SSD 7317 MODIFICATION 3 – RESPONSE TO SUBMISSIONS

This Response to Submissions report (RTS) is submitted to the (the Department) in support of Modification 3 to amend State Significant Development (SSD) consent SSD – 7317 relating to the construction of a commercial campus at the Australian Technology Park, Eveleigh.

1 DA GFA - BELOW GROUND
1 : 300

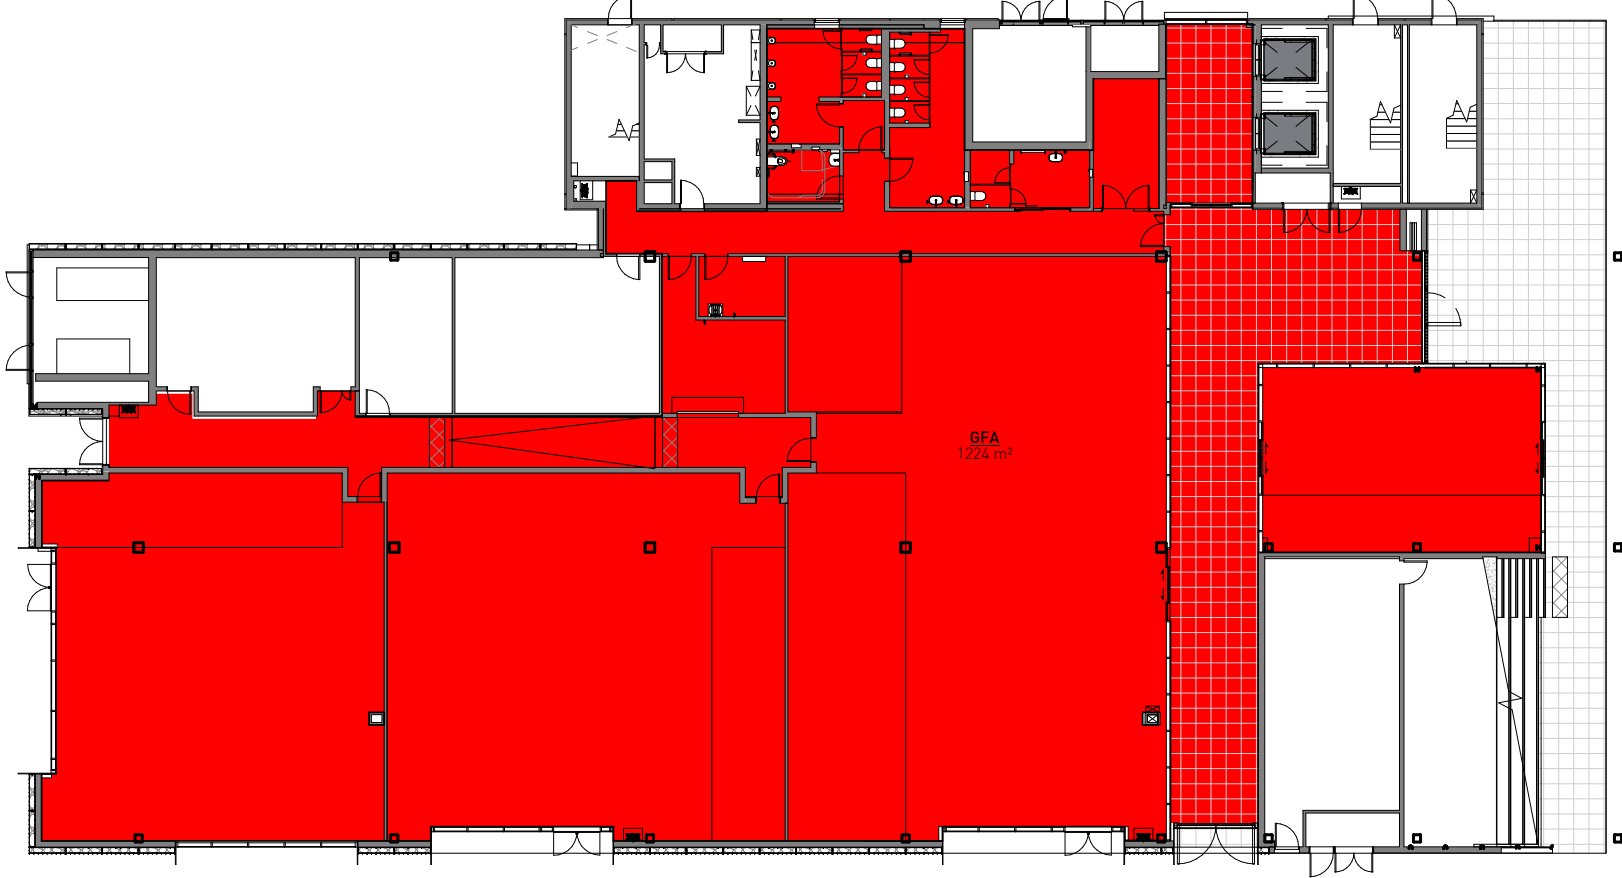
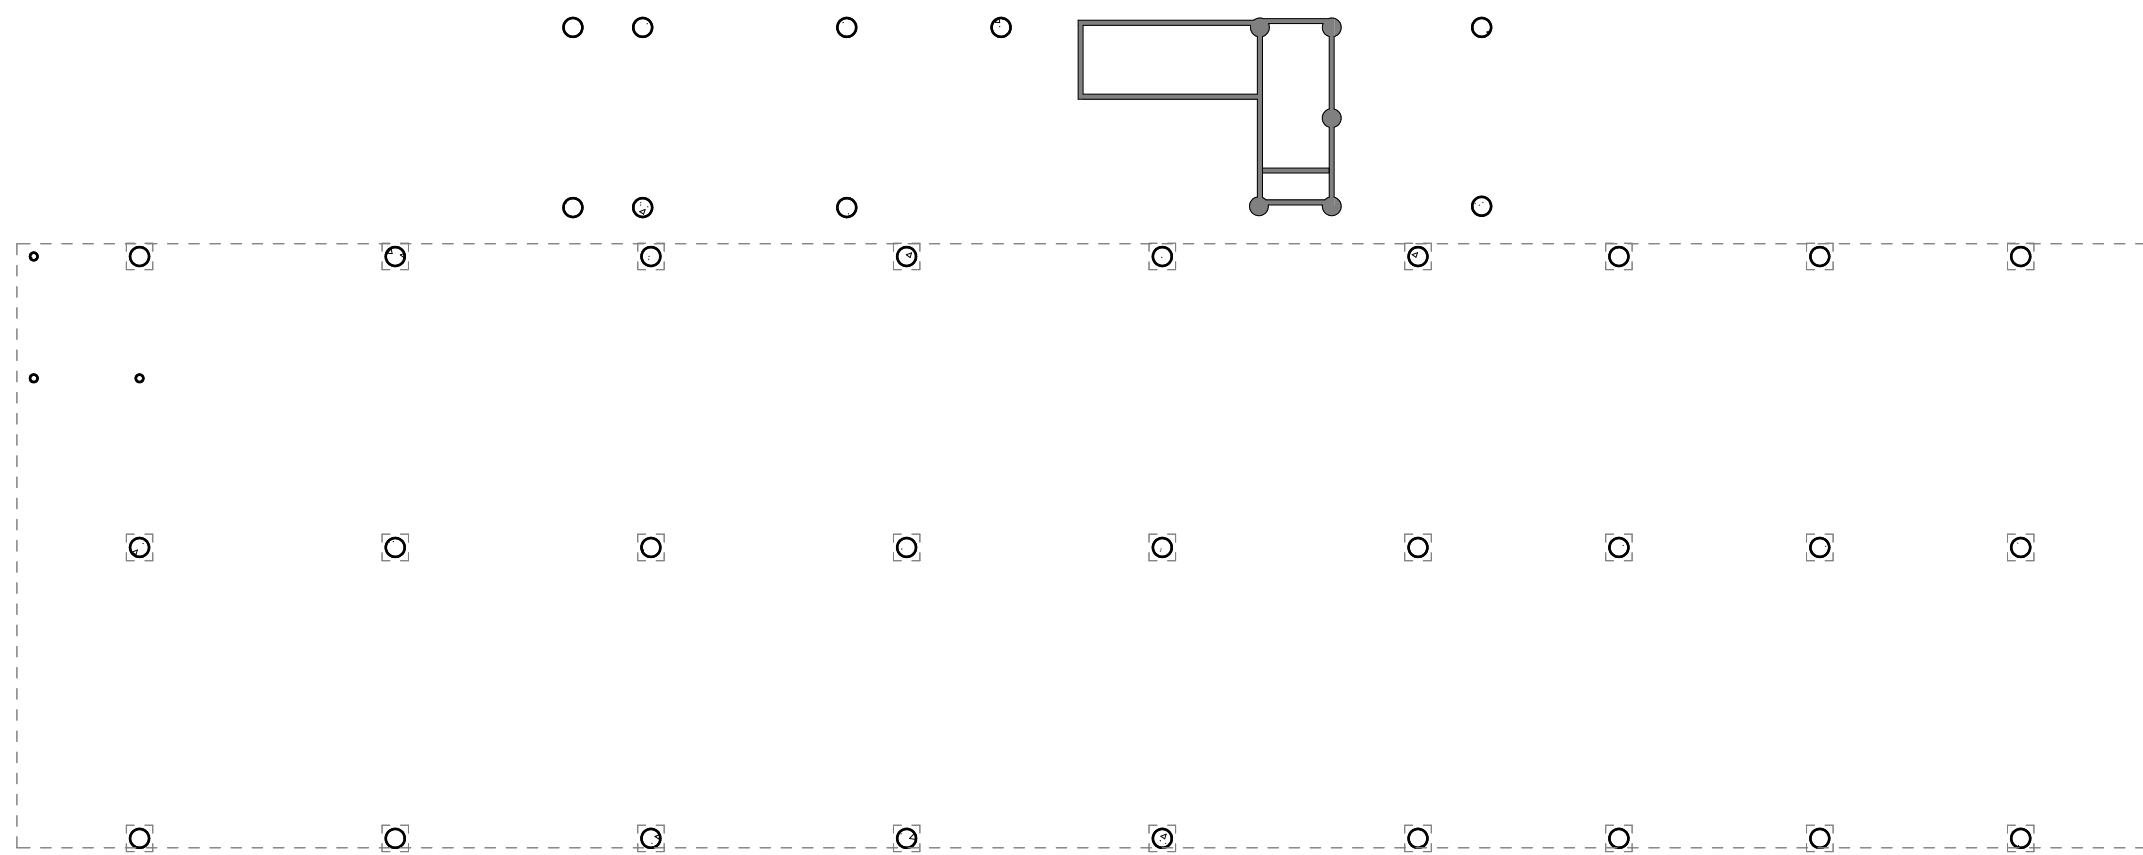
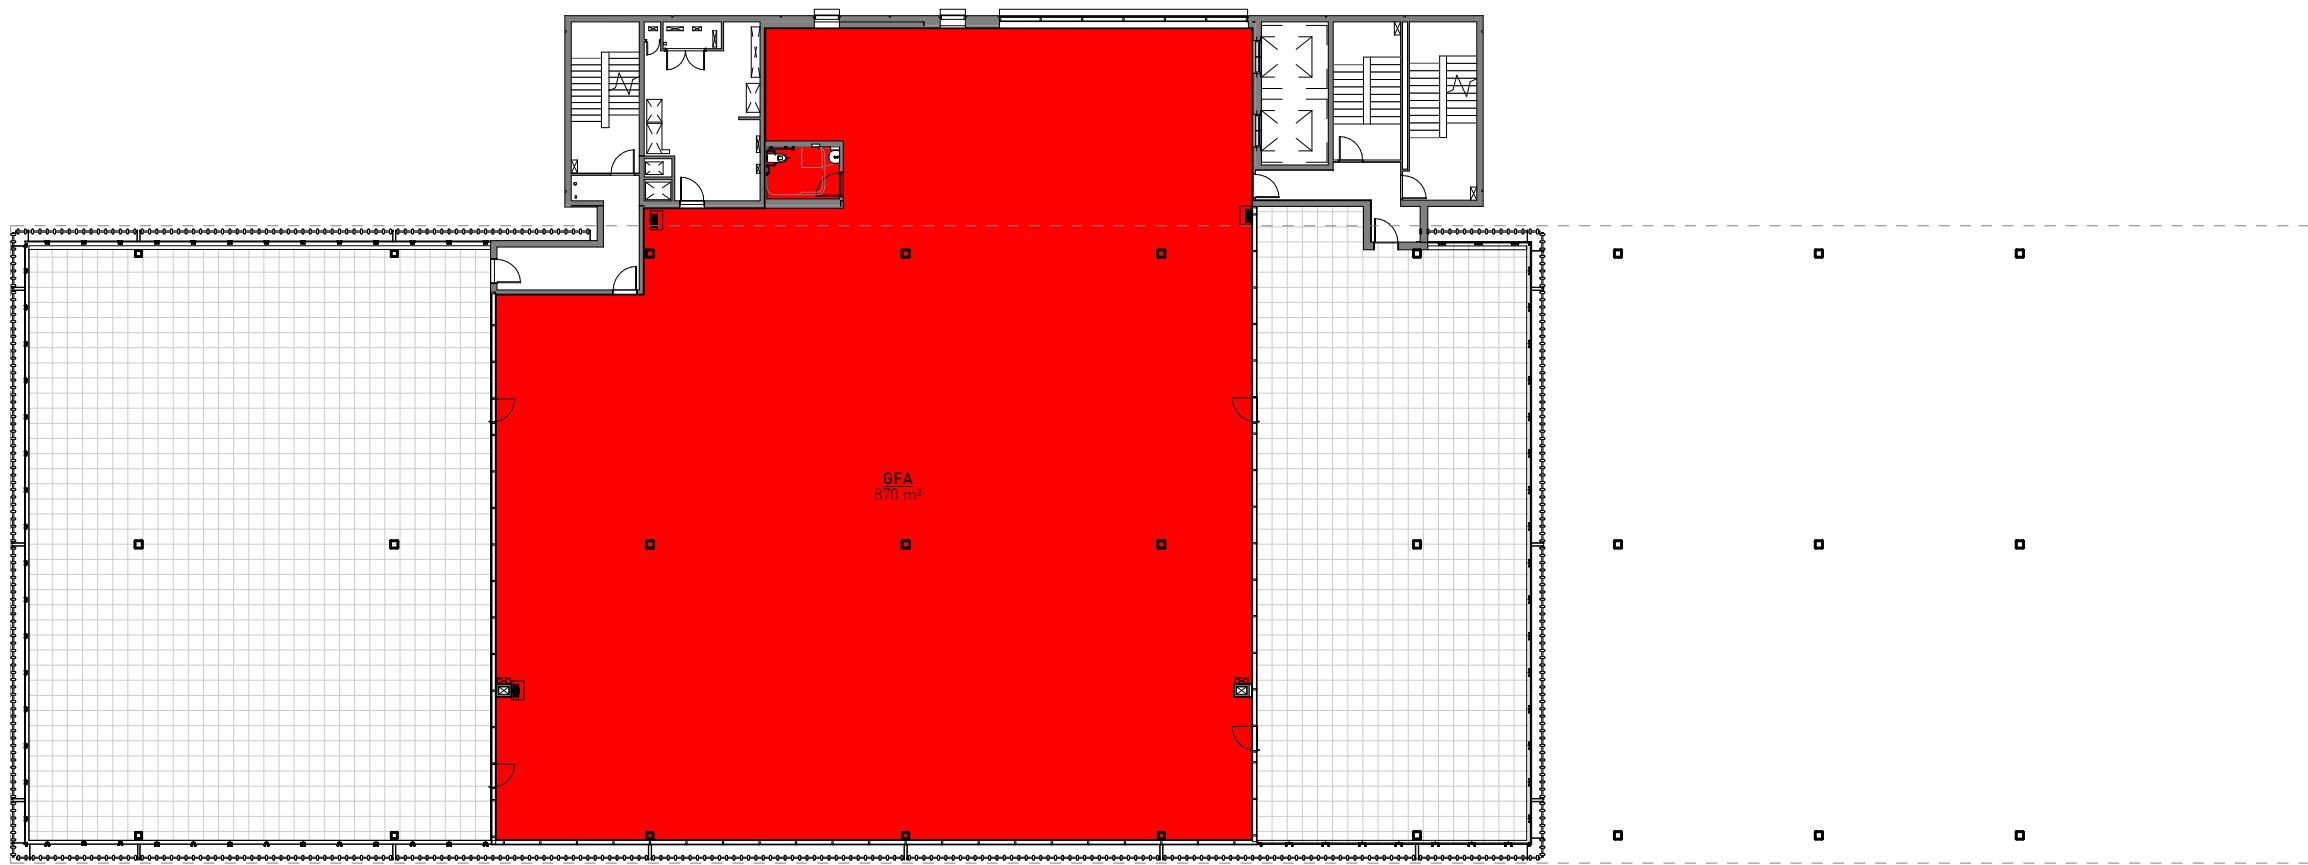
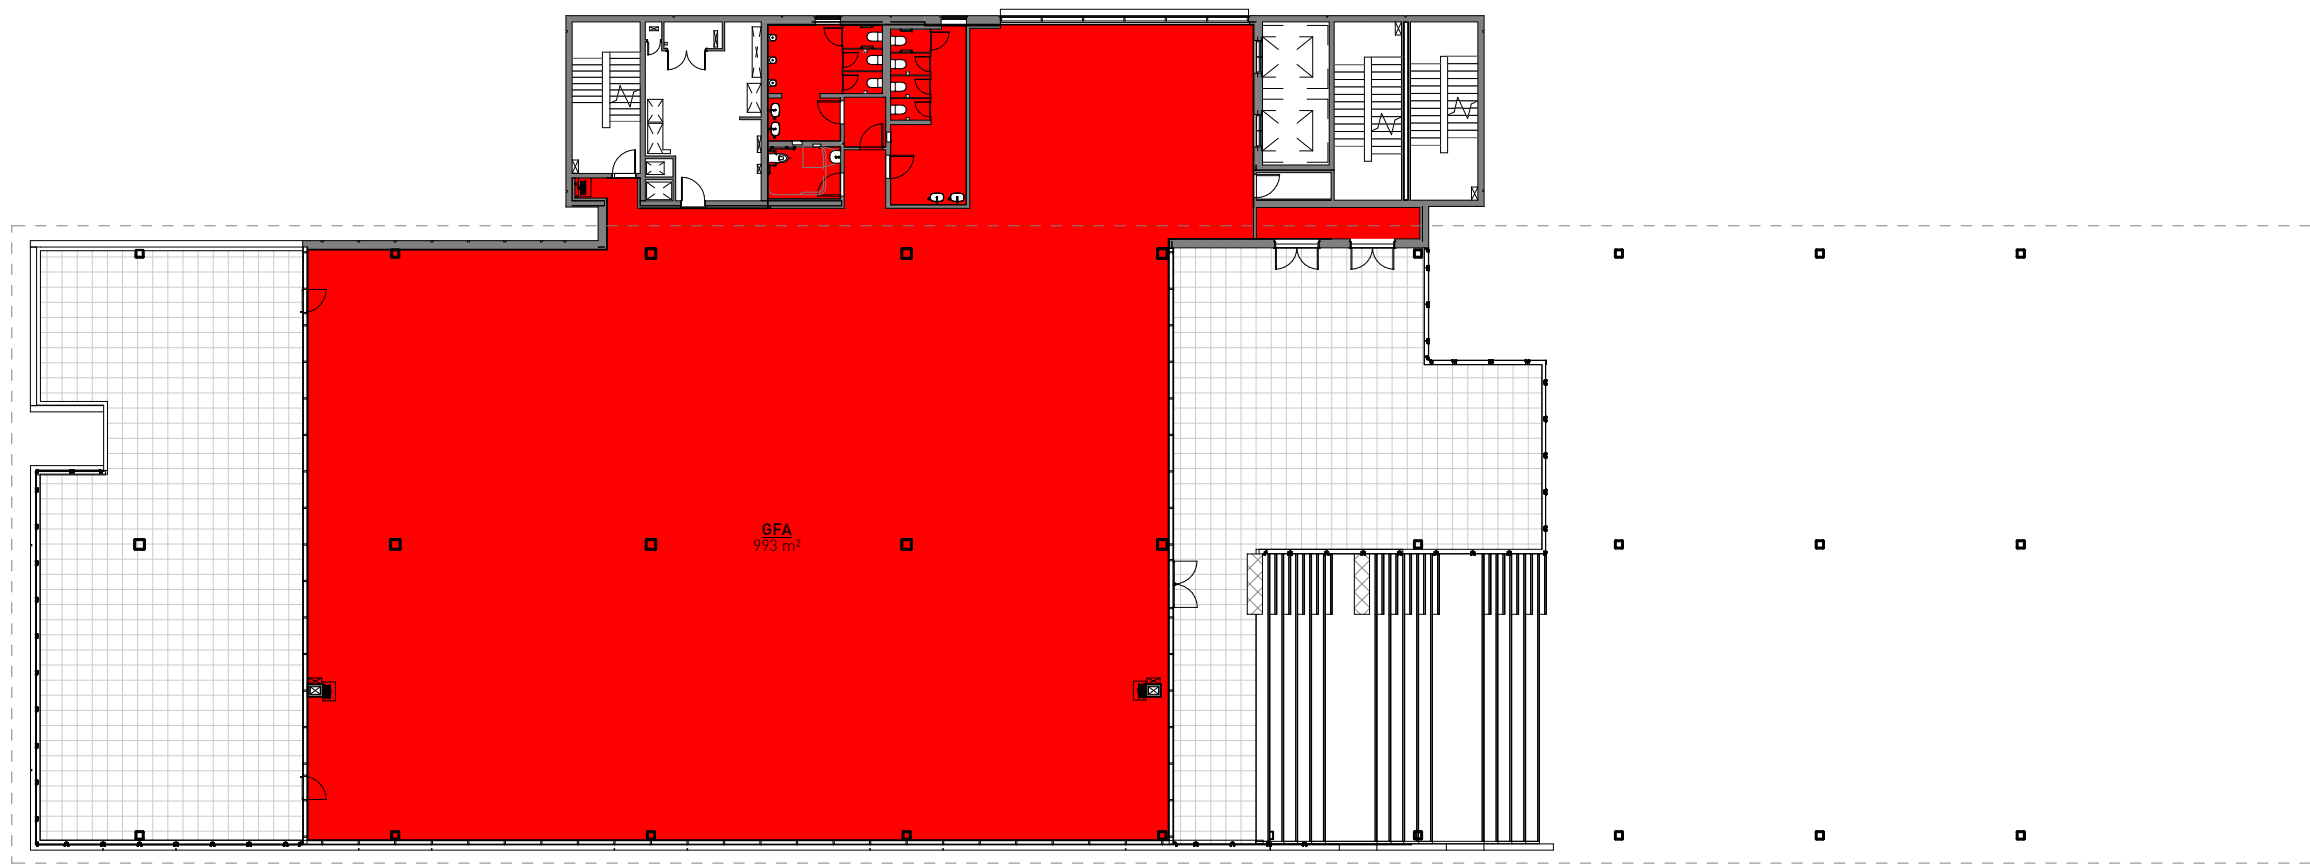
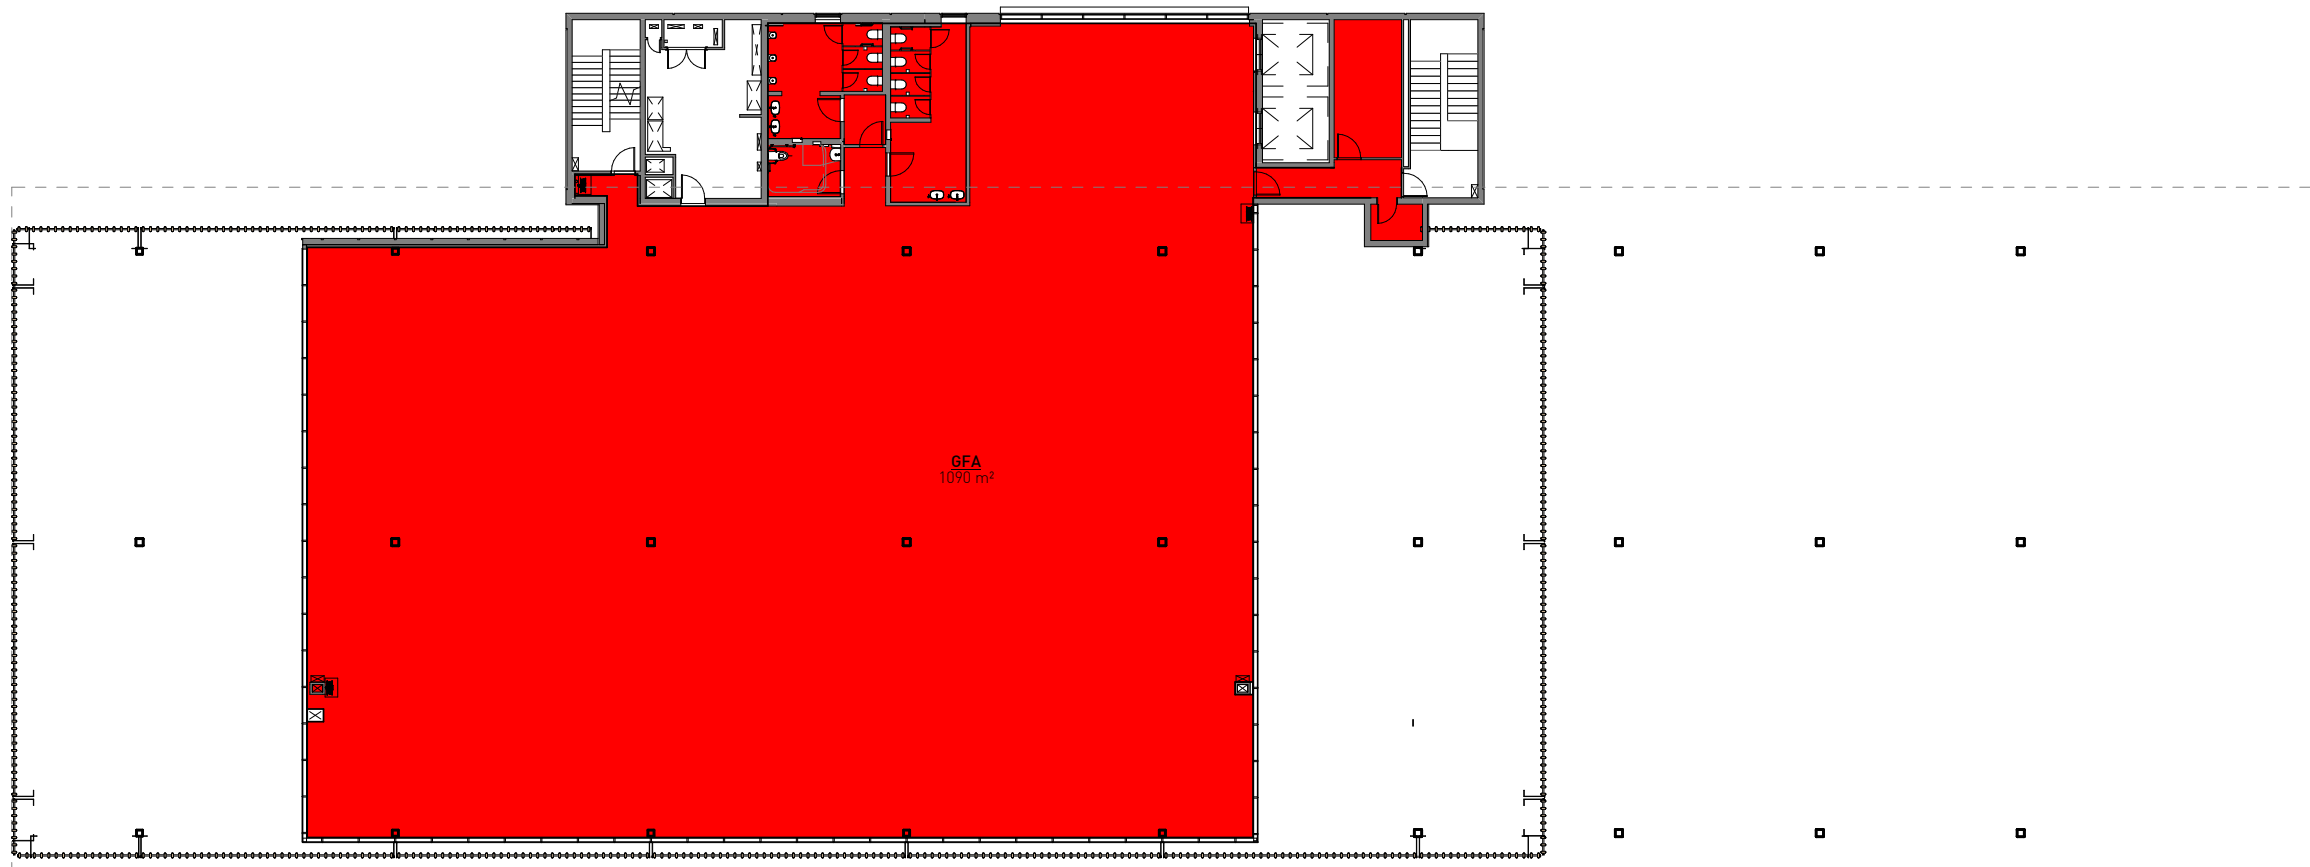
Item	Response
Provide a further GFA Plan comparing the approved GFA (in APS_400 Rev 1, dated 19.07.17) with the proposed GFA, showing the location of the additional GFA sought.	Refer to the attached comparison plans showing the approved GFA and the proposed GFA.
Update the overshadowing diagrams to show the extent of overshadowing from the proposed changes to the building (i.e. comparing the shadow cast between approved and proposed buildings).	Refer to the attached June 21 overshadowing plans which highlight the approved overshadowing and the proposed overshadowing. Between 9am and 12 noon, the proposed overshadowing is reduced along the western edge of Davy Road, however extends slightly further south along the carriageway. This ensures that the pedestrian footpath on the western side of Davy Road receives sunlight from 10am. Between 1pm and 3pm the existing and proposed shadows are generally consistent, with the proposed shadows only extending further south onto Henderson Road at 3pm.
